**98th Street Warehouse**  
98th and Central  
Traffic Circulation Layout

**Response to review dated November 2, 2022**

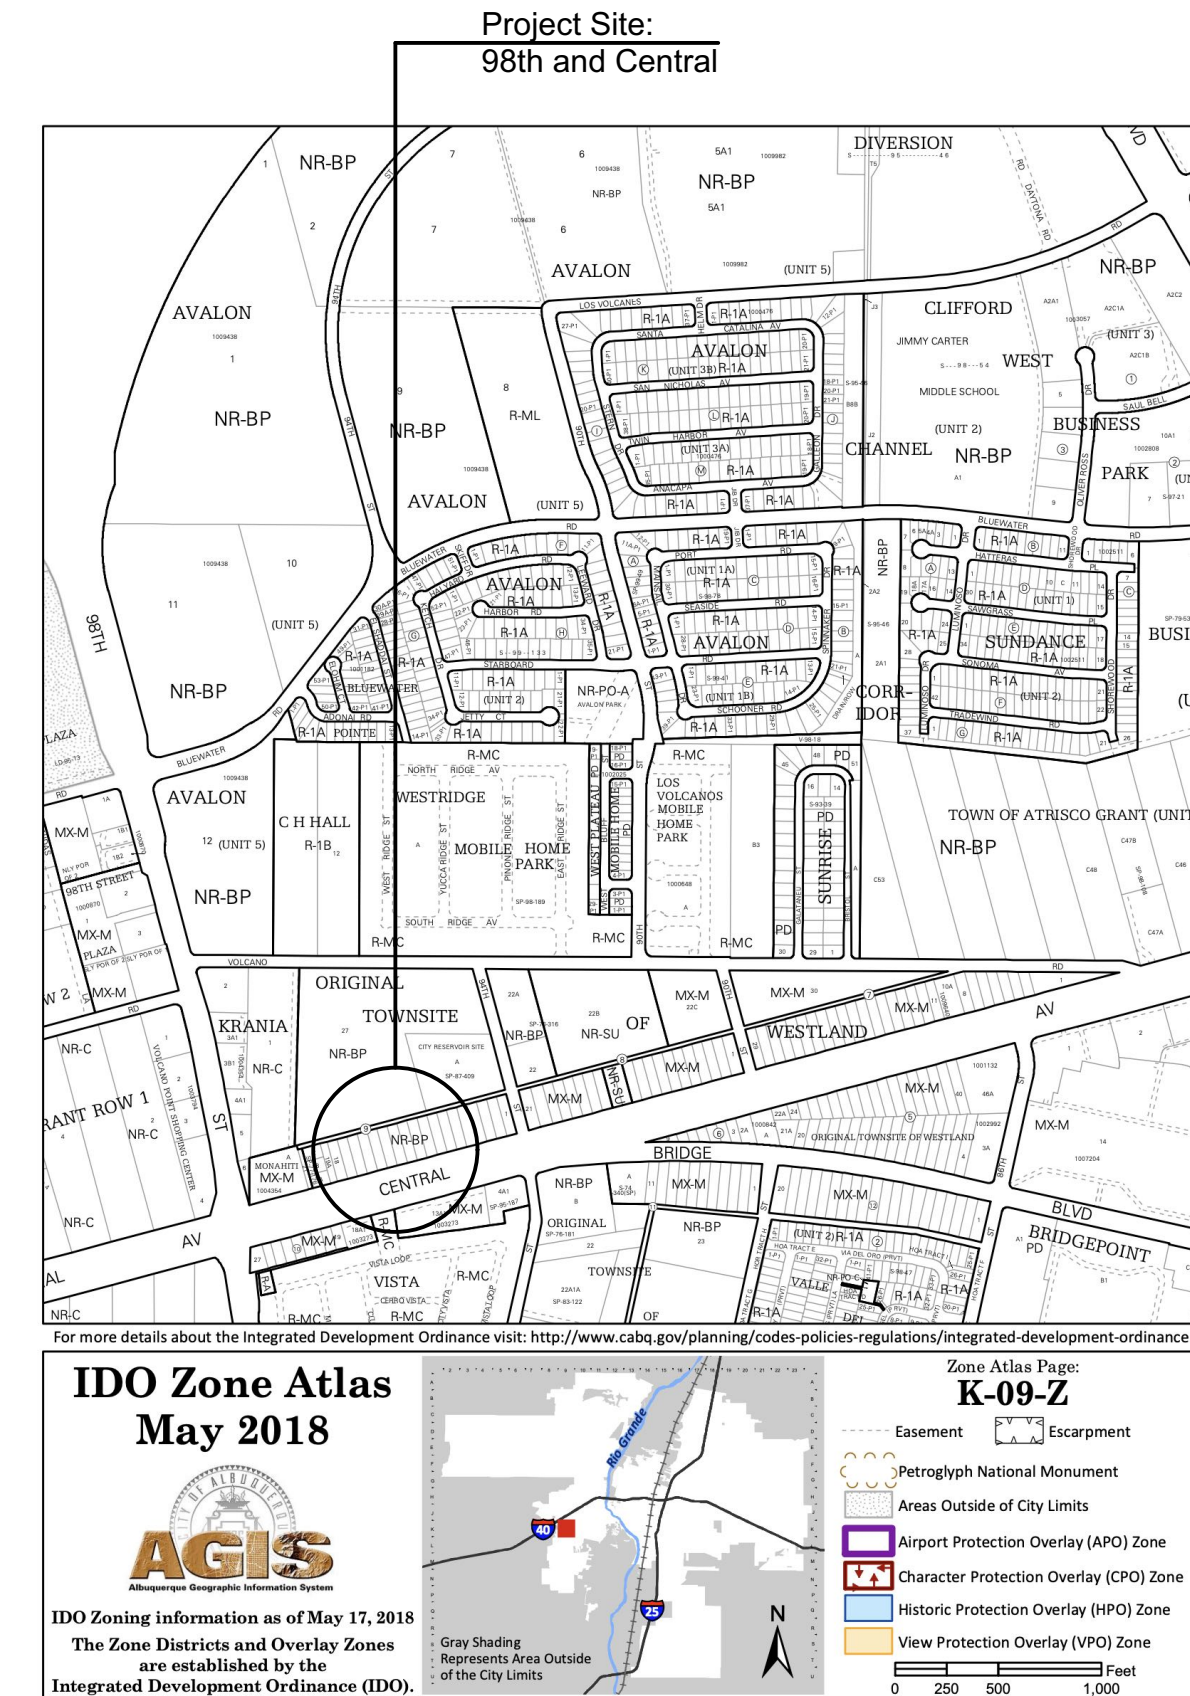
1. The curb at the site access points is per CoA DWG 2425- not sure what your asking for?
2. Corrected - see plan
3. Corrected - see plan
4. Attached
5. Attached
6. See note #8
7. See note #1/2/3
8. No work in public ROW except drive pad entrances- see new note #13
9. see new note #13
10. Attached
